**REQUEST**

Current Zoning: B-2(CD) (general business, conditional)  
Proposed Zoning: B-2(CD) SPA (general business, conditional, site plan amendment)

The petition proposes to amend a previously approved rezoning plan (2017-182) to allow the previously approved carwash as a principle use in an alternate location on the site.

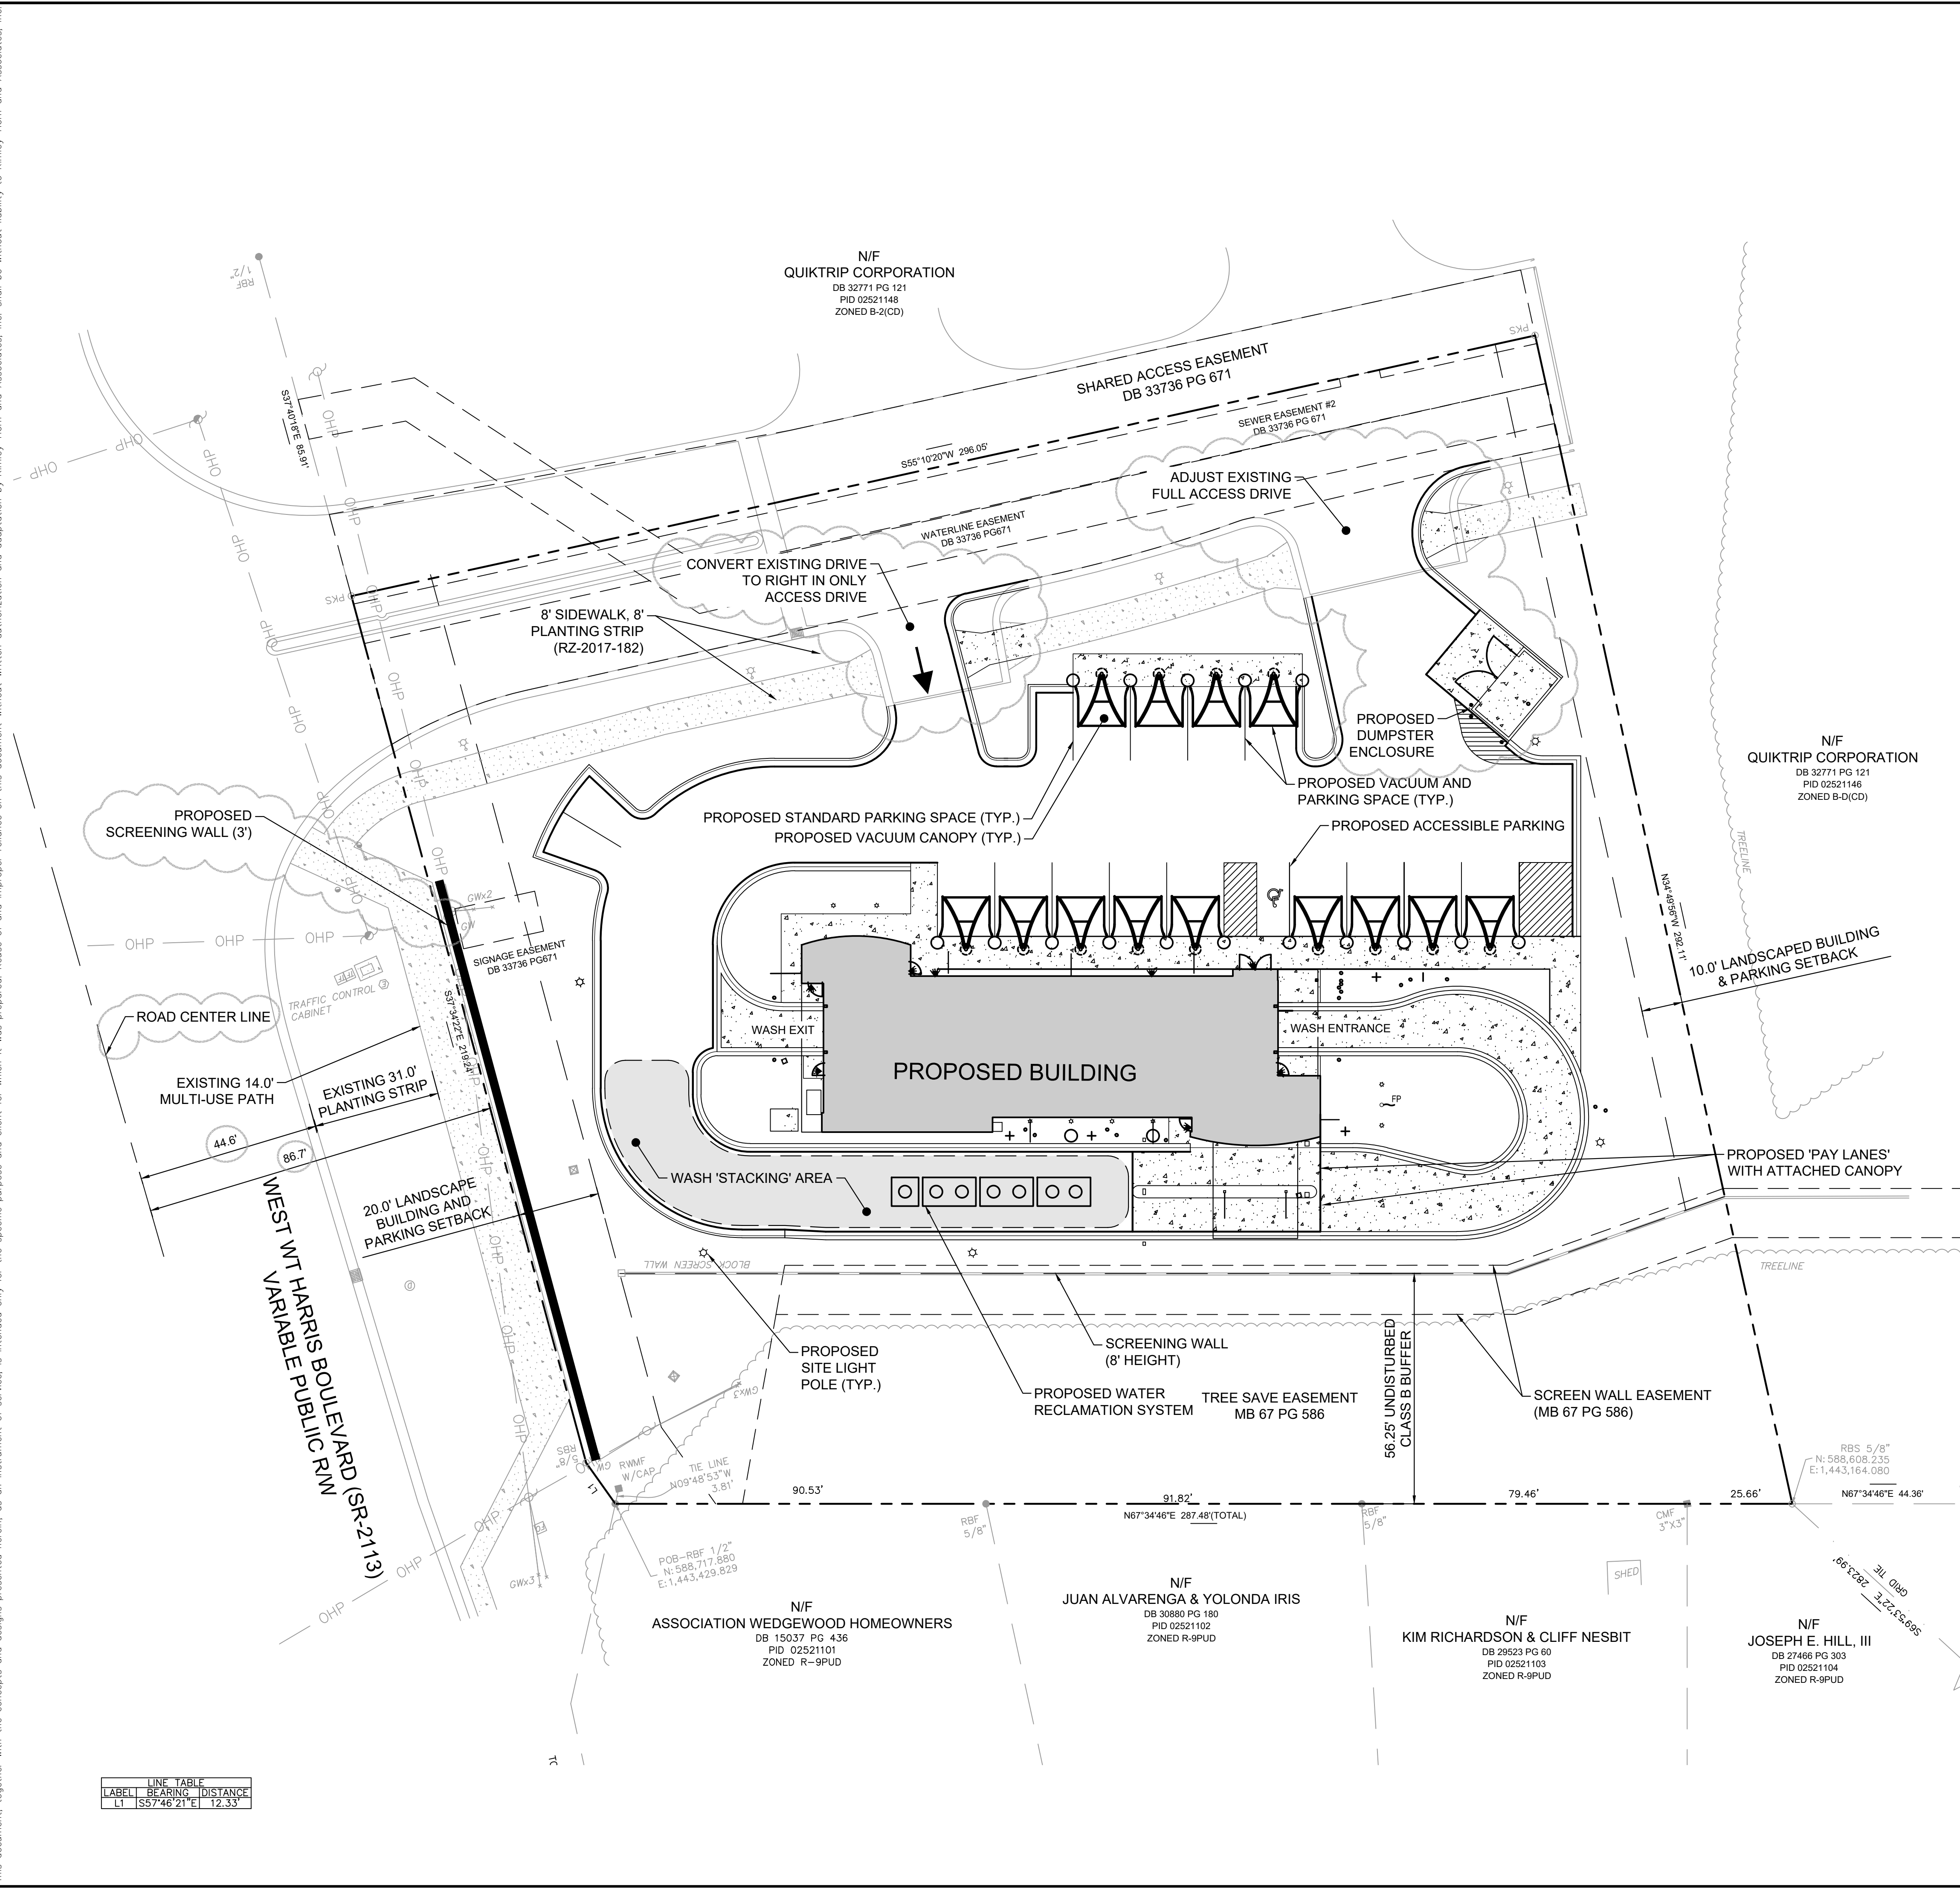
1. Either remove the right in only driveway and keep the full access drive or keep the right in only access driveway and convert the full access drive to egress only. Revise conditional note 2f. to update this language to match the revised driveway design.

2. Revise the site plan and conditional note(s) to incorporate the minor conditional note corrections below.

- b. THE PLACEMENT AND CONFIGURATION OF THE VEHICULAR ACCESS POINTS ARE SUBJECT TO ANY REVISIONS REQUIRED TO ACCOMMODATE FINAL SITE DEVELOPMENT AND CONSTRUCTION PLANS AND TO ANY ADJUSTMENTS **or NCDOT** APPROVAL BY CDOT IN ACCORDANCE WITH APPLICABLE PUBLISHED STANDARDS.

- c. THE ALIGNMENT OF THE INTERNAL VEHICULAR CIRCULATION AND DRIVEWAYS MAY BE MODIFIED BY THE PETITIONER TO ACCOMMODATE CHANGES IN TRAFFIC VOLUMES, PARKING LAYOUTS AND ANY ADJUSTMENTS REQUIRED FOR APPROVAL BY CDOT IN ACCORDANCE WITH PUBLISHED STANDARDS. **or NCDOT**

- d. THE PETITIONER WILL CONSTRUCT REQUIRED ROADWAY IMPROVEMENTS AND PROVIDE ANY REQUIRED SIDEWALK AND UTILITY EASEMENTS NEEDED FOR THESE IMPROVEMENTS PRIOR TO THE ISSUANCE OF THE FIRST CERTIFICATE OF OCCUPANCY, SUBJECT TO THE PETITIONER'S ABILITY TO REQUEST THAT CDOT ALLOW A BOND TO BE FORWARDED TO CDOT FOR IMPROVEMENTS NOT FINALIZED AT THE TIME OF THE ISSUANCE OF THE CERTIFICATE OF OCCUPANCY, AS ALLOWED BY **sidewalk utility easement**

- e. THE PETITIONER WILL DEDICATE VIA FEE SIMPLE CONVEYANCE ANY REQUIRED RIGHT-OF-WAY INDICATED ON THE REZONING PLAN AS RIGHT-OF-WAY TO BE DEDICATED. THE ADDITIONAL RIGHT-OF-WAY WILL BE DEDICATED PRIOR TO THE ISSUANCE OF THE FIRST CERTIFICATE OF OCCUPANCY. THE PETITIONER WILL PROVIDE A PERMANENT SIDEWALK EASEMENT FOR ANY OF THE PROPOSED SIDEWALKS LOCATED ALONG THE PUBLIC STREETS LOCATED OUTSIDE OF THE RIGHT-OF-WAY. THE PERMANENT SIDEWALK EASEMENT WILL BE LOCATED A MINIMUM OF TWO (2) FEET BEHIND THE SIDEWALK WHERE FEASIBLE.
